Our Ref: A/123/26/NMA

Non material amendment following the grant of A/88/24/S73 to swap in new house type range.

Land North of Water Lane Angmering

Coloured Street Scenes - A to E
Land North of Water Lane, Angmering

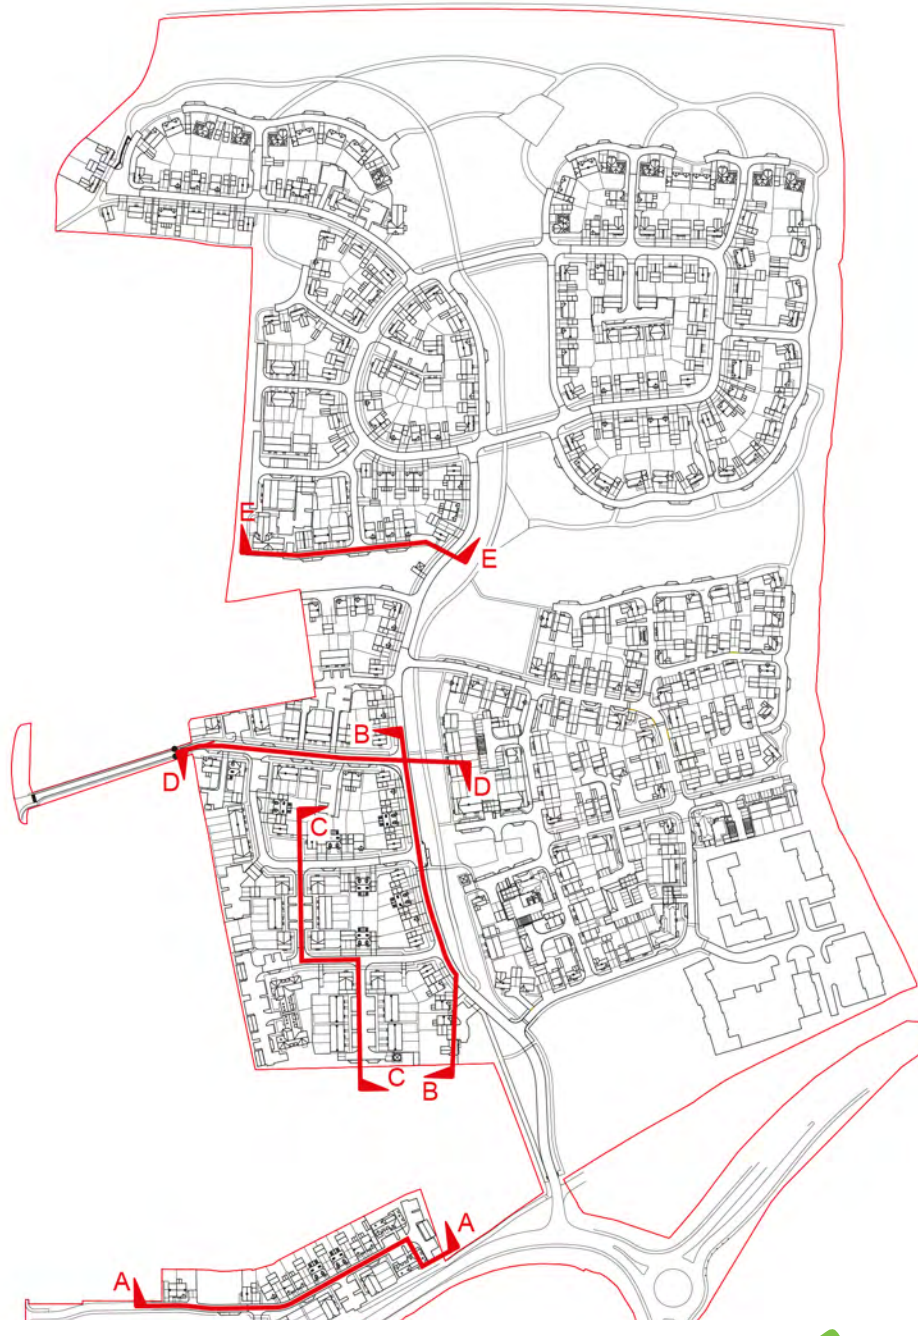
The amendments would result in minor alterations to the appearance and external materials of the affected dwellings. No changes are proposed to the number of bedrooms, building heights, or overall scale of the units. Furthermore, no additional habitable-room windows are proposed that would overlook neighbouring properties or result in any material loss of privacy.

C105 rev B Coloured Street Scenes A to E (sheet 1 of 3) (Dated July 2026)

CLIENT:	Rydon Homes Ltd / Gleeson Land	PROJECT:	Land North of Water Lane Angmering
SCALE:	1:100 (A1 ORIGINAL)	DRAWING:	Plot 348 Proposed Plans and Elevations
DRAWN:	AM	19271	P216
DATE:	Oct '21		B

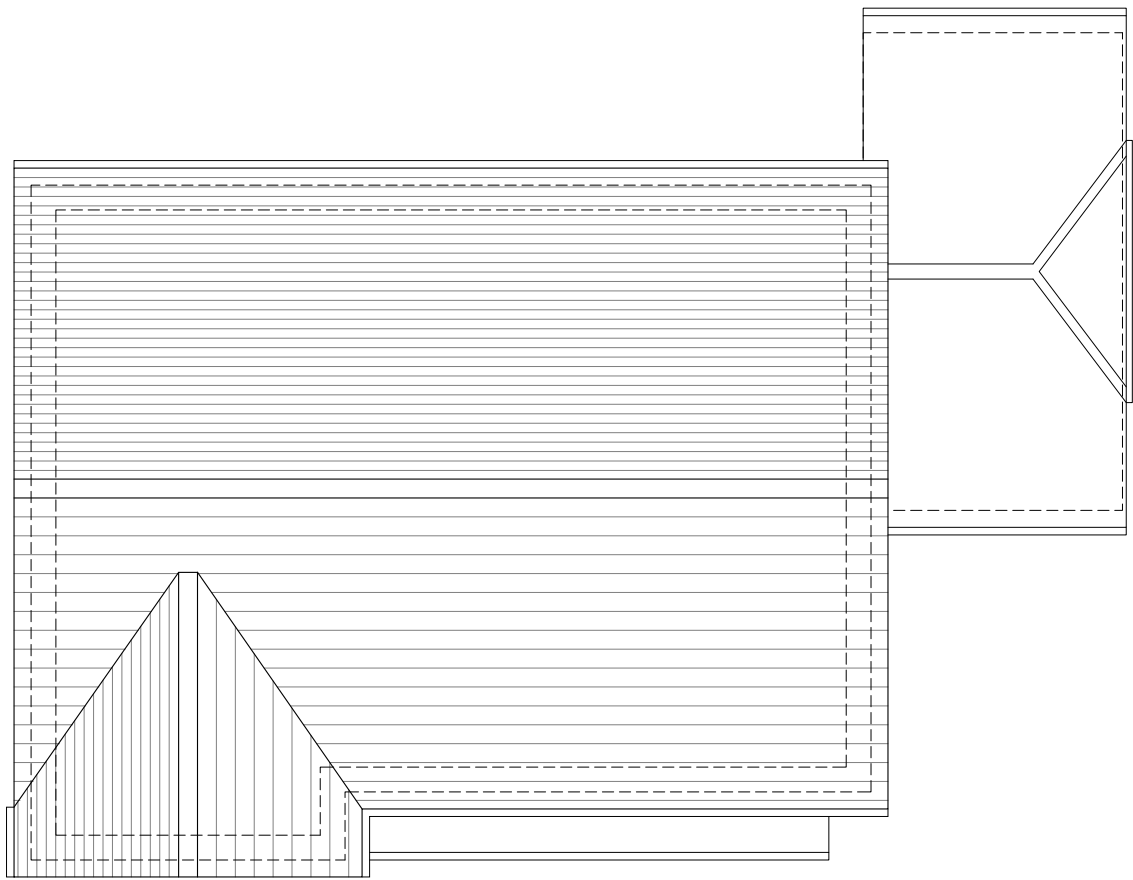
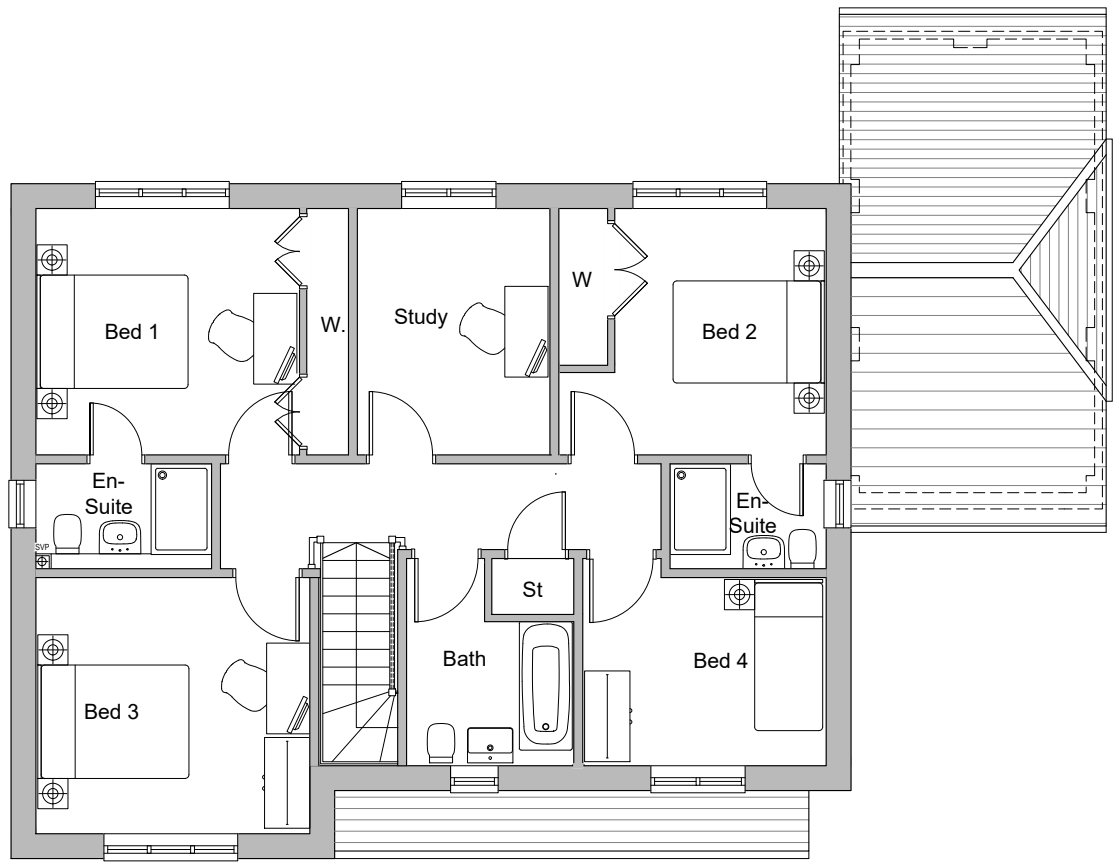
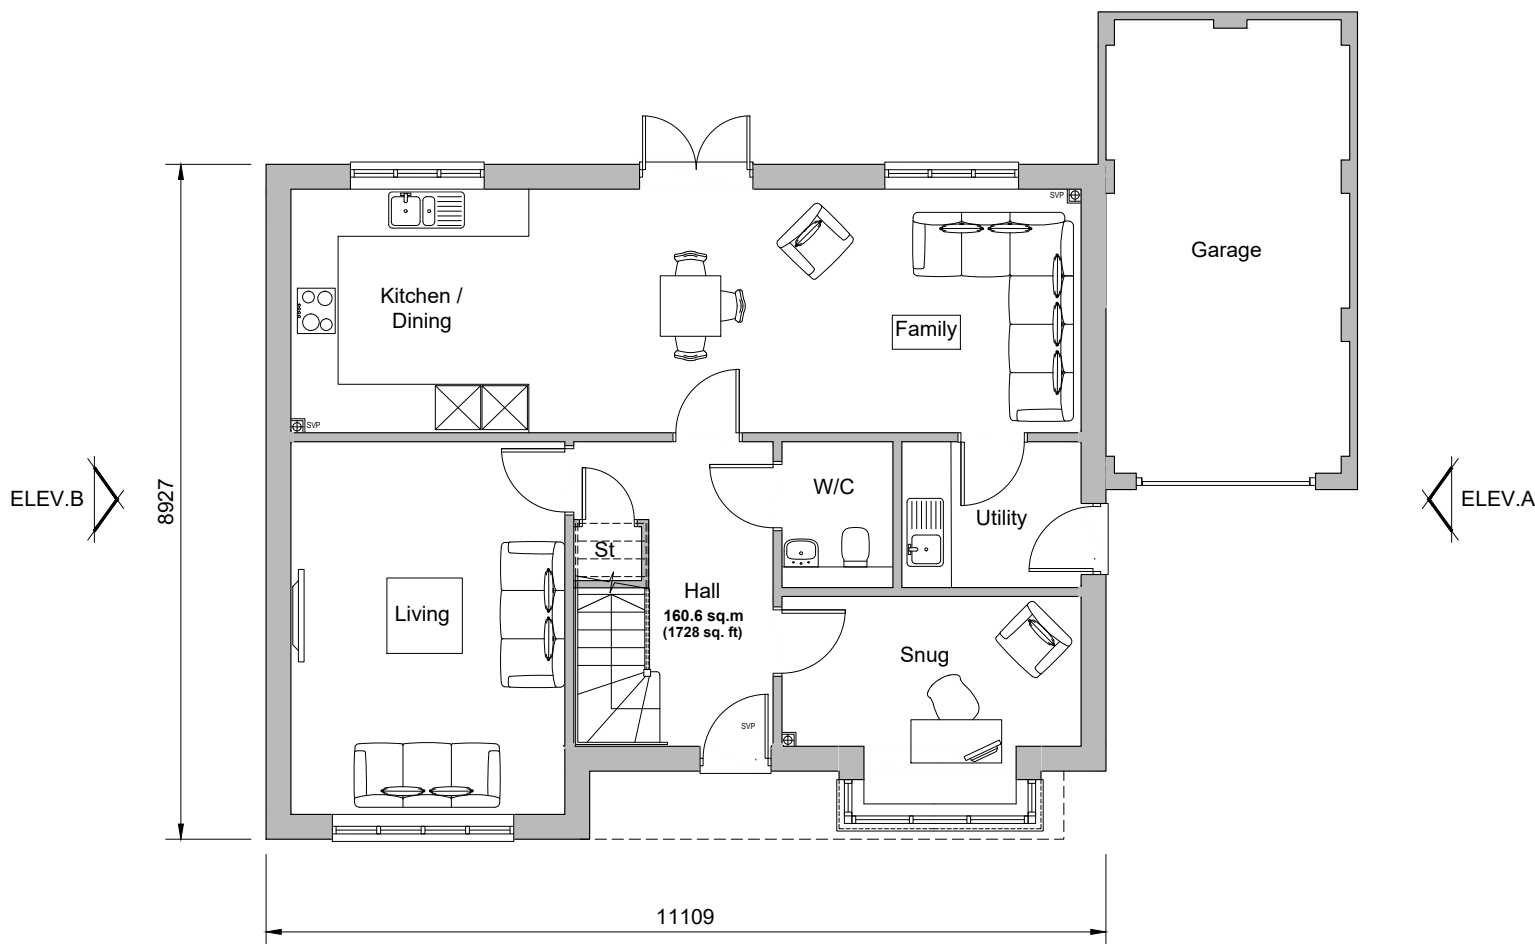
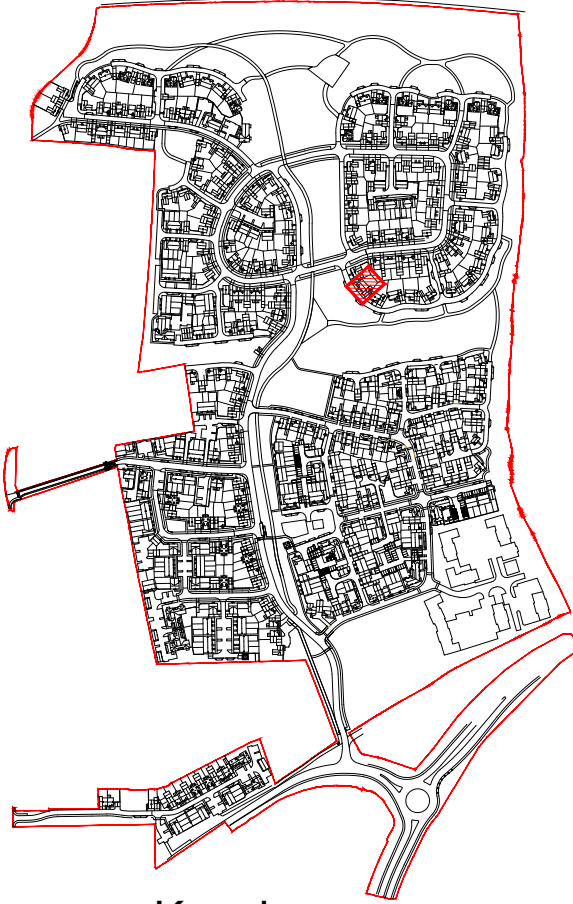
Walnut to New Walnut (10 plots): 293, 294, 295, 306, 309, 325, 327, 348, 349 and 350.

P216 rev B Plot 348 - Plans and Elevations (Dated July 2026)

CLIENT:	Rydon Homes Ltd / Gleeson Land	PROJECT:	Land North of Water Lane Angmering
SCALE:	1:100 (A1 ORIGINAL)	DRAWING:	Plot 180 Proposed Plans & Elevations
DRAWN:	BH	19271	P284
DATE:	Jul '26		-

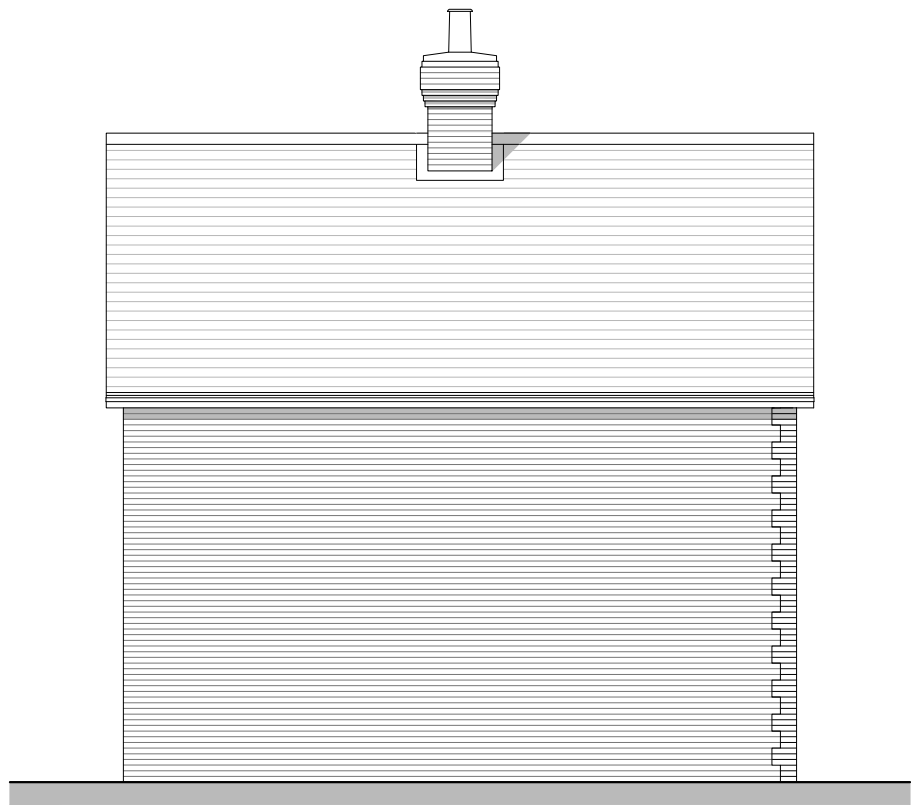
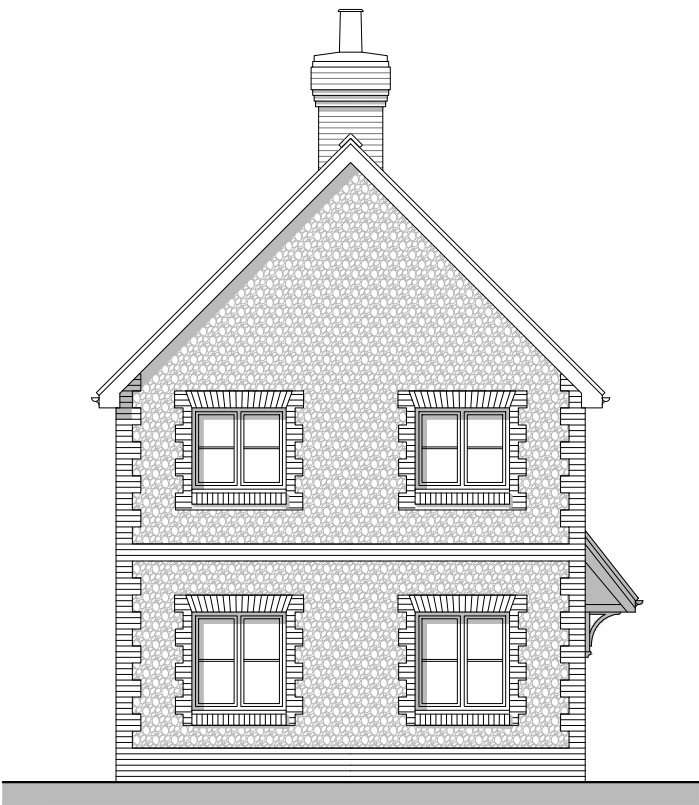
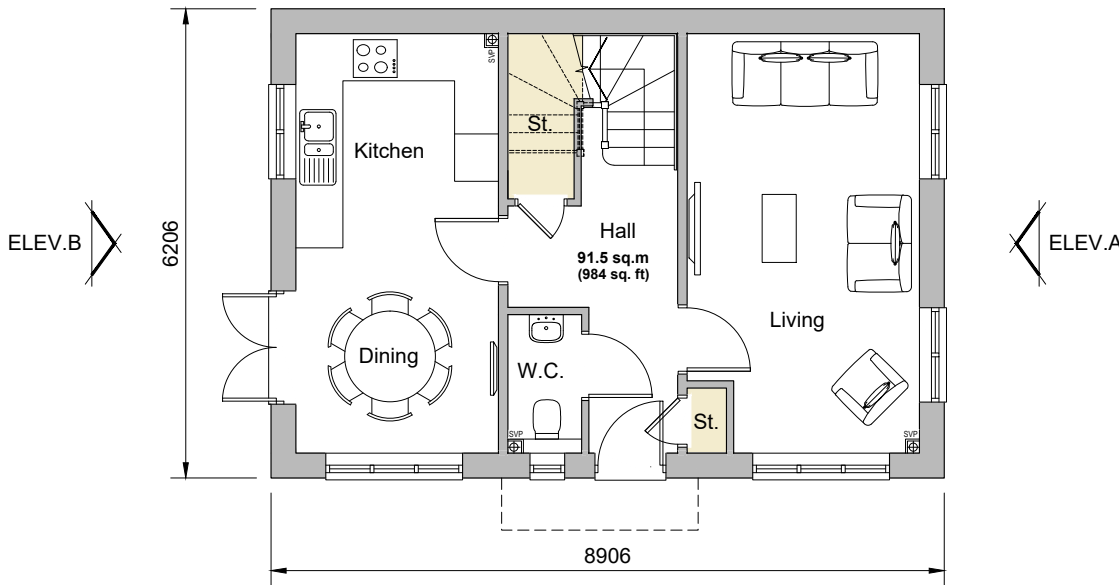
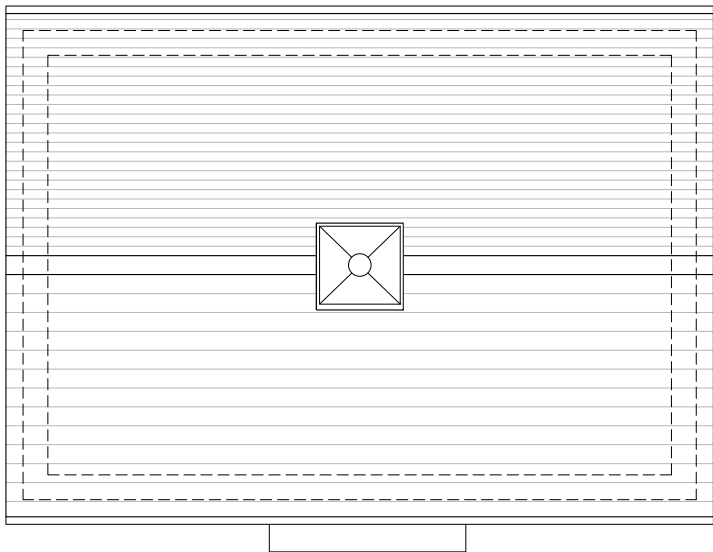
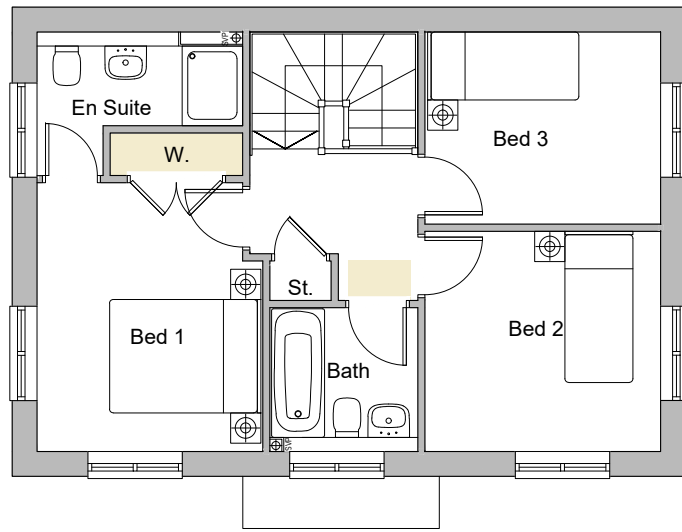
Chestnut to New Chestnut (11 plots): 173, 176, 180, 291, 299, 304, 311, 314, 319, 330 and 341.

P284 Plot 180 - Plans & Elevations (Dated July 2026)
